File: SF17/40830
Job ID: DOC17/428136
Your Ref: SSD 7037

RE: Heritage Council comments on Response to Submissions (rts) and variation to the Sydney Cove Redevelopment Authority Scheme for Proposed Mixed-Use Redevelopment and Adaptive Re-Use of Heritage Buildings at The Rocks (SSD 7037).

Rajeev Maini
Manager Conservation
Heritage Division
Office of Environment & Heritage
As Delegate of the NSW Heritage Council
15 September 2017

3 PLAN Level 1
1:500

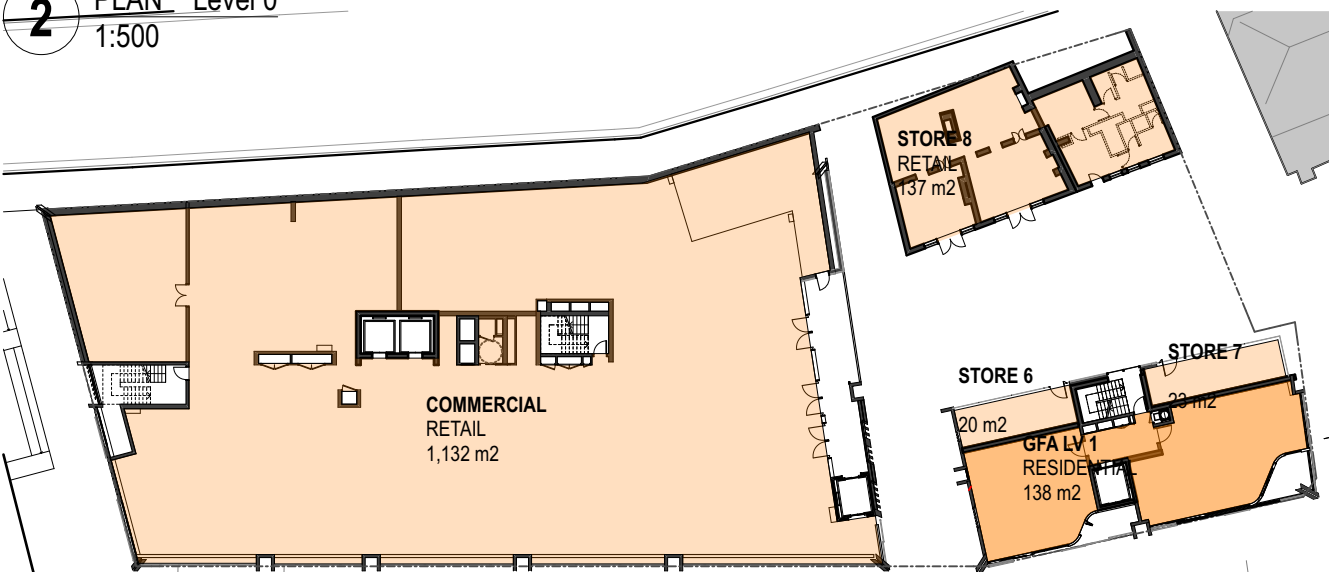
The information submitted has been reviewed. The recommended condition below is reiterated because the proposal has not been amended or addressed satisfactorily in the supporting documents in response to the Heritage Council's previous recommendation:

- **Submit to the Department of Planning and Environment for assessment and approval a revised architectural drawing of No. DA-2002 with title 'Plans Level 1 Floor Plan' revision P, prepared by Francis-Jones Morehen Thorp Pty Ltd dated 4/08/2016. The revision shall include retention of all other fabric (basement walls) that has been assigned a significance grading of *High* and *Exceptional* in the basement of the Bakers Terraces; as indicated in supporting document entitled *Conservation Management Plan, Bakers Terrace, 66-68 & 70-72 Gloucester Street, The Rocks*, prepared by Urbis Pty Ltd dated January 2016 (reference p100).**
